**MECKLENBURG COUNTY**  
**Land Use & Environmental Services Agency**

**MEMORANDUM**

To: Charlotte-Mecklenburg Planning Commission  
From: Dylan J. Kirk, Mecklenburg County LUESA  
Date: November 2, 2020  
Subject: Initial Rezoning Petition Comments

**2020-140: RJS Properties, Inc.**

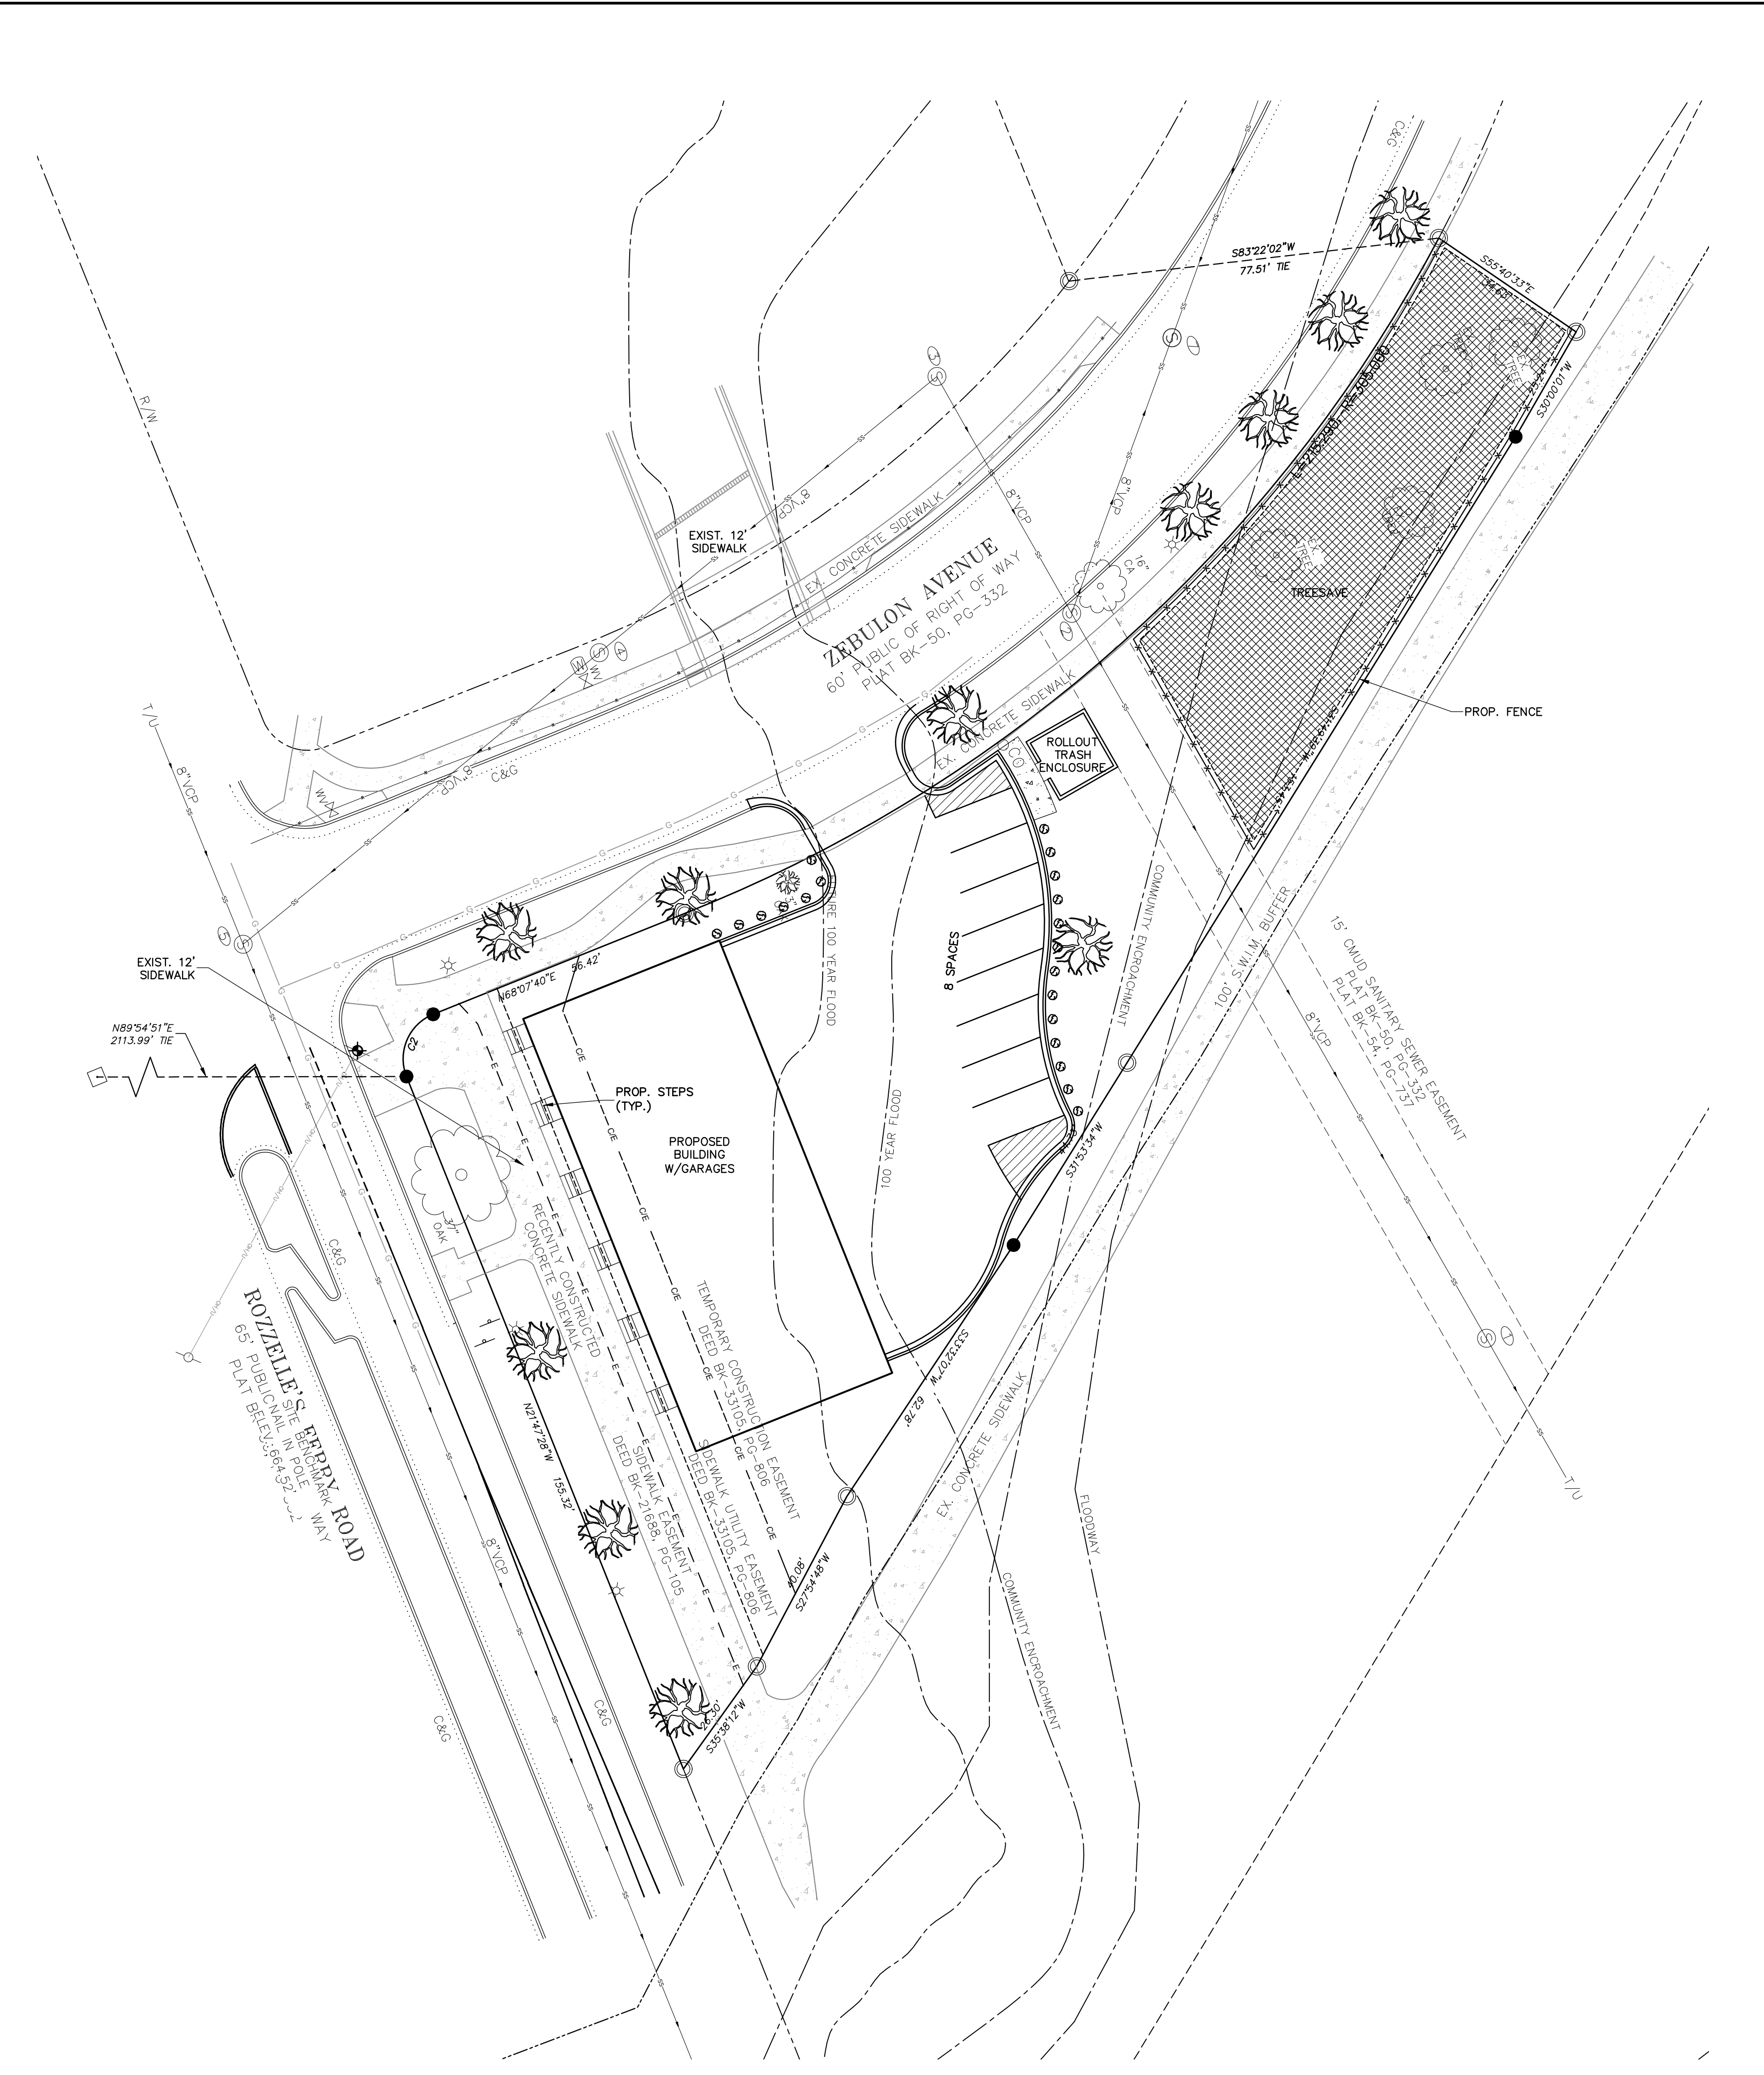
*Ground Water Services Comments:* Groundwater & Wastewater Services records indicate contamination site(s) exist on or within 1,500 feet of the property included in the petition. An established Area of Regulated Groundwater Usage (ARGU) as defined by the Mecklenburg County Groundwater Well Regulations extends 1,500 feet around the contamination sites. In an ARGU where municipally supplied water is available water supply wells for potable water supply, irrigation or open loop geothermal systems may not be permitted or constructed on or within 1,000 feet of contamination sites. Wells may be permitted with special construction and sampling requirements between 1,000 and 1,500 feet of contamination sites.

*Storm Water Services Comments:* A Floodplain Development permit must be obtained documenting compliance with the City of Charlotte Floodplain Regulations for all development occurring in the

floodplain. In addition, staff recommend any structures proposed within the Community Special Flood Hazard Area be constructed to a Flood Protection Elevation equal to the Community Base Flood Elevation plus two (2) feet of freeboard based upon recent analyses of the future floodplains supported by the Storm Water Advisory Committee.
